**Deadline 7 submission to Planning Inspectorate, National Infrastructure Planning: Ref. TR010025**

Prepared by Dr. G.M. Reeves for the **Stonehenge Alliance. Ref.2001870**

**Part two: Summary of fundamental failures in Highways England’s ground characterisation of proposed A303 Tunnel and Road Project with ref to REP5-003, Section 11.1, Oral Submissions**

PROPOSED BORED TUNNEL - (WORK No. 1F)

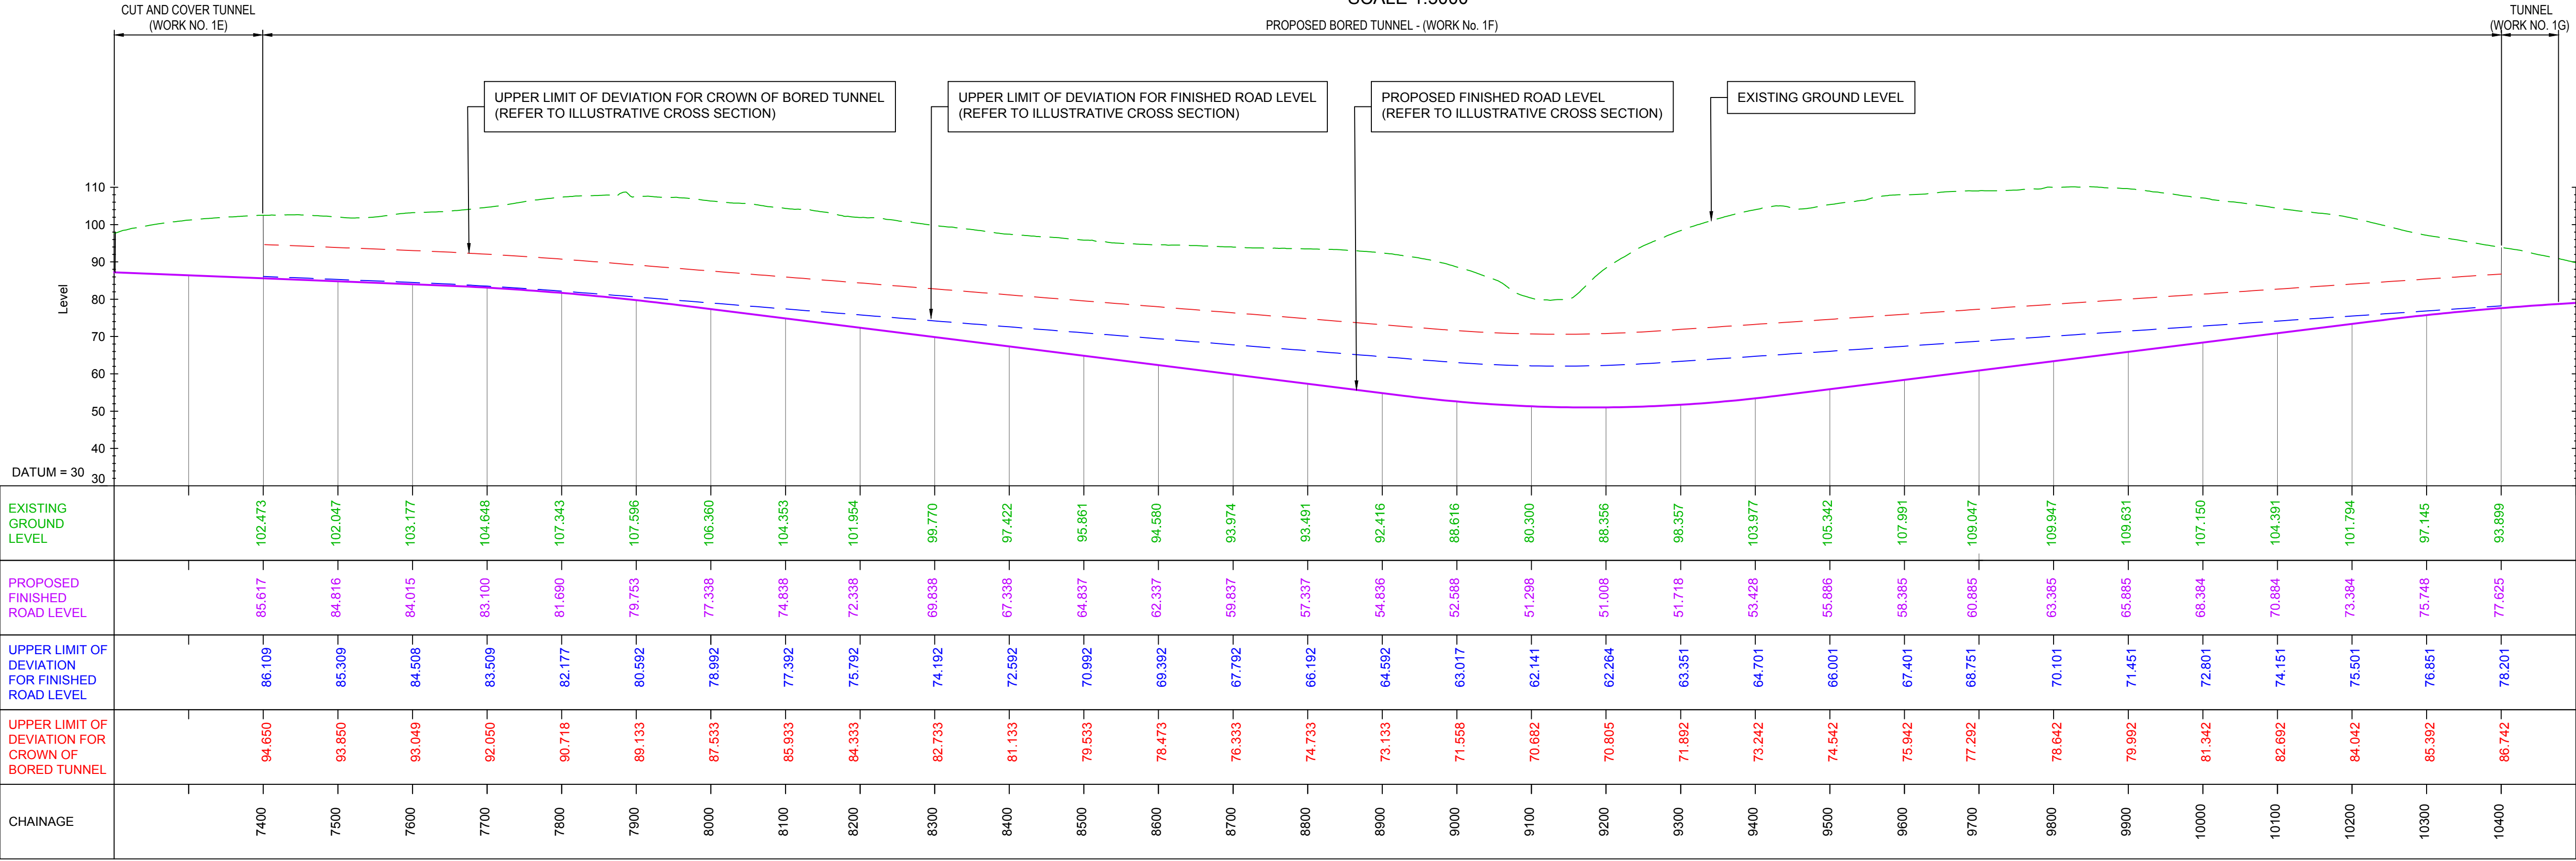
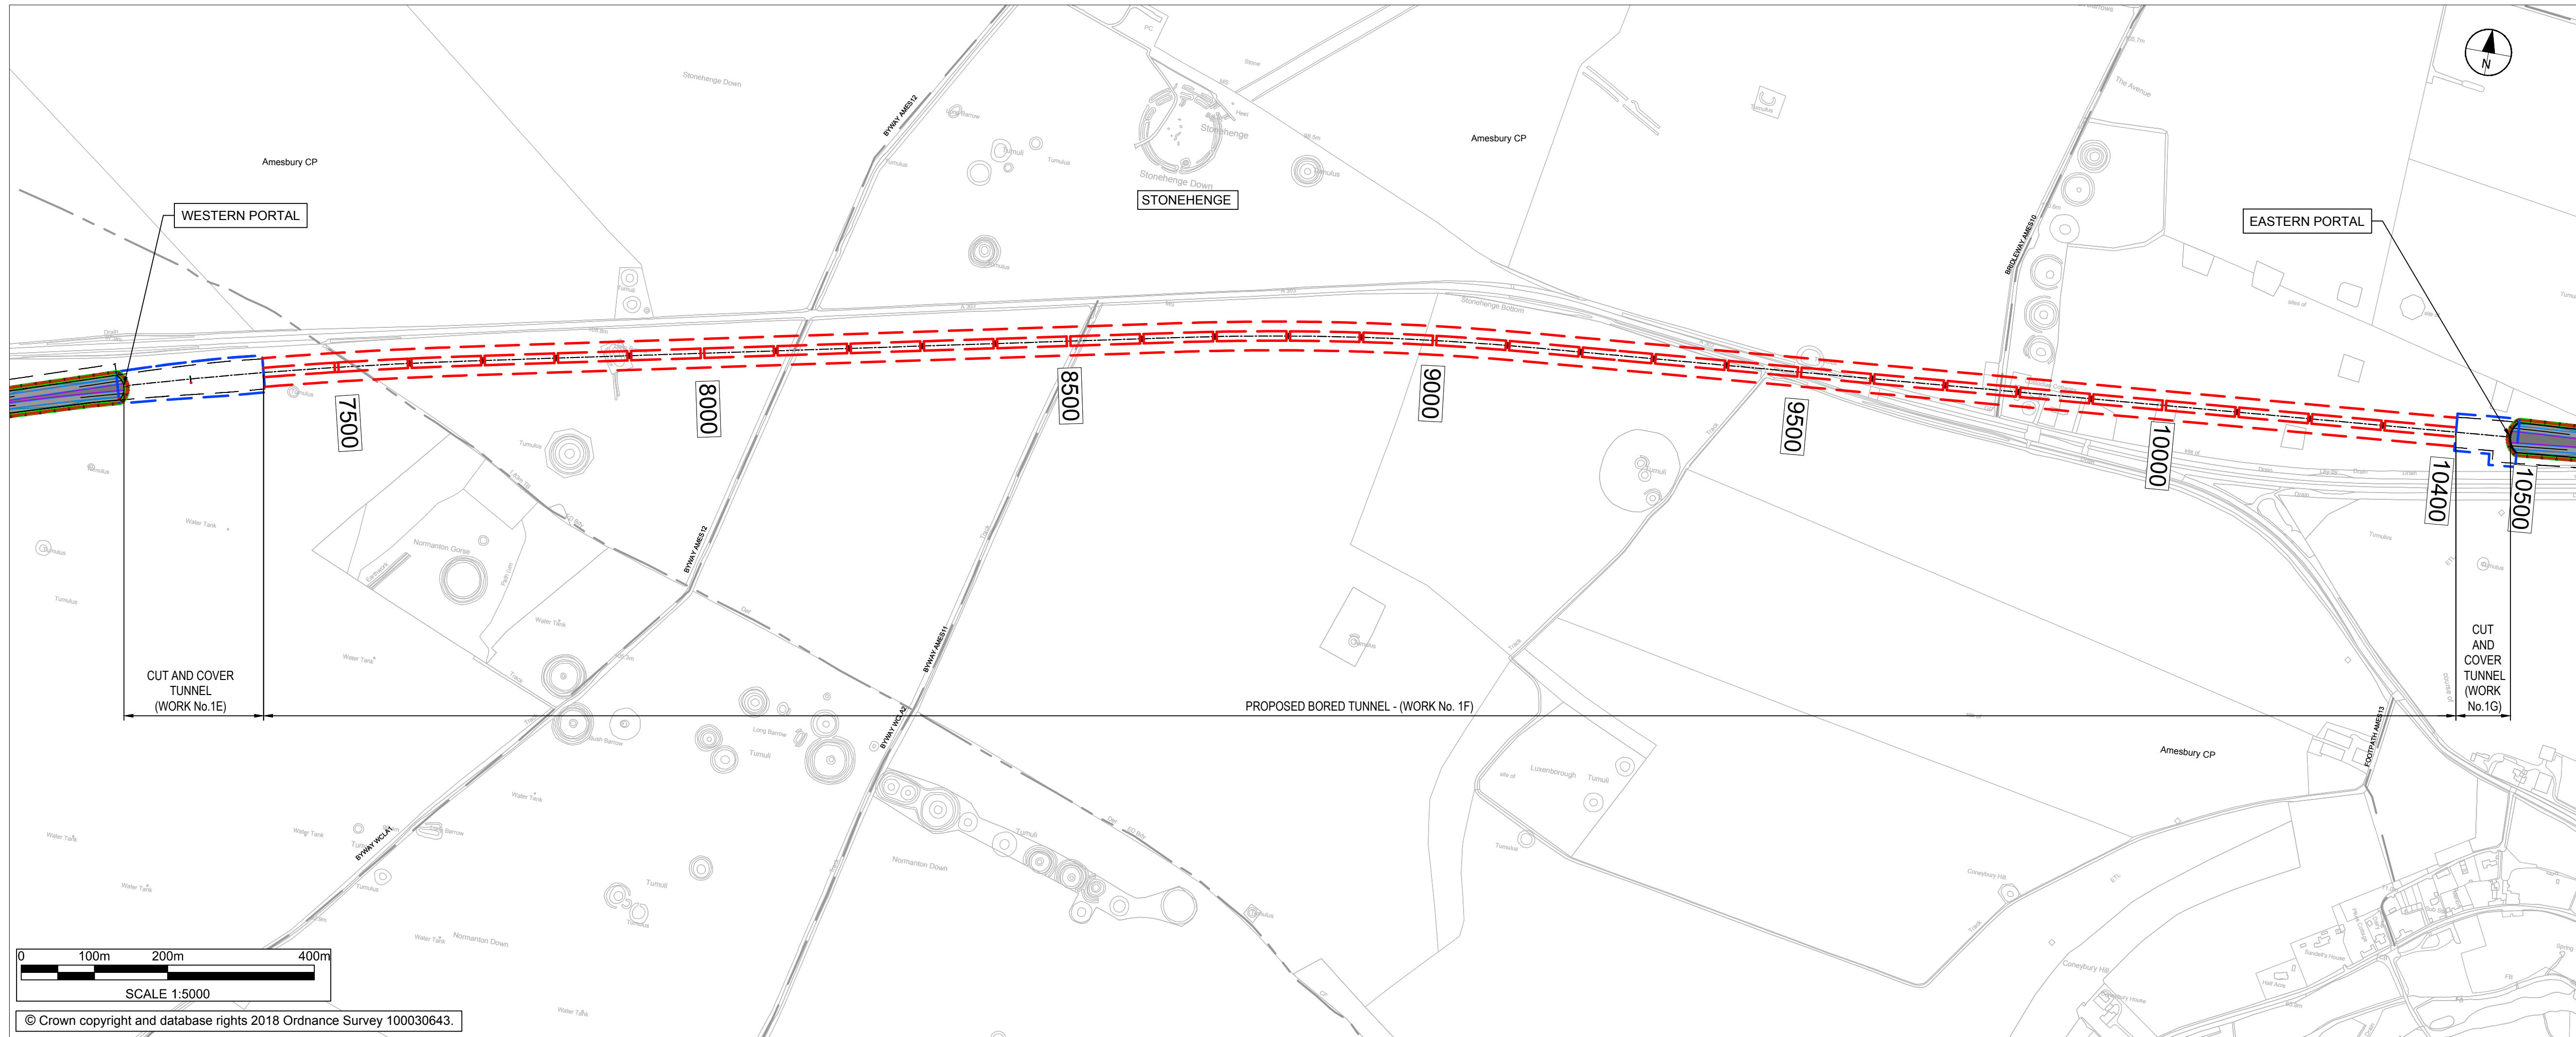
The short and long term stability of the weaker horizons of both the Newhaven and especially the Seaford Chalk remain problematic. In particular, the Phosphatic Chalk found in the Seaford Chalk sequence (found mostly in the western section of the proposed tunnel), shows properties of rapid degradation and disintegration (in 3 to 9 days), as shown in the Stonehenge Alliance presentation to the ExA of June 11<sup>th</sup> (Dr. GM Reeves; Slides 6,7 and 8; Borehole R501, 18.75 to 21m and 24.00 to 27.50 metres depth).

As displayed in Mortimore et al., 2017 ( Figure 25, reproduced below), at various borehole locations and depths along the original proposed tunnel line (slightly to the south along the western portion of the current proposed tunnel route), weak Phosphatic Seaford Chalk was identified as a potential instability problem along the tunnel line and especially at and above the tunnel face.

However, as can be seen on Figure 2, page 12 of this report (reproduced above), the Whitway Rock (“if present”, and controlling lateral groundwater movement as seen further to the east, and especially in the Blick Mead/Amesbury Abbey spring system) could be a significant problematic feature during the proposed tunnel construction which has yet to be fully and thoroughly investigated by HEng.

1. The engineering properties, “Stand-up Time”, excavatability, rock strength (over days and weeks, unsupported) of the critical sections and depths of the Upper Seaford Phosphatic Chalk “bodies” have neither been fully investigated, nor detailed or presented in any relevant reports by Highways England (HEng).

3. High groundwater levels, in anything other than high summer drought conditions, are likely to hamper tunnelling, and in the event of possible varied and adverse induced groundwater chemistries, could cause potential additional degradation of the Phosphatic Chalk in particular, with possible solution, piping conditions and migration of voids to surface.

4. The Whitway/Stockbridge Rock/Barrois Horizon zone of high horizontal elevated permeability must be specifically investigated throughout the proposed project area.
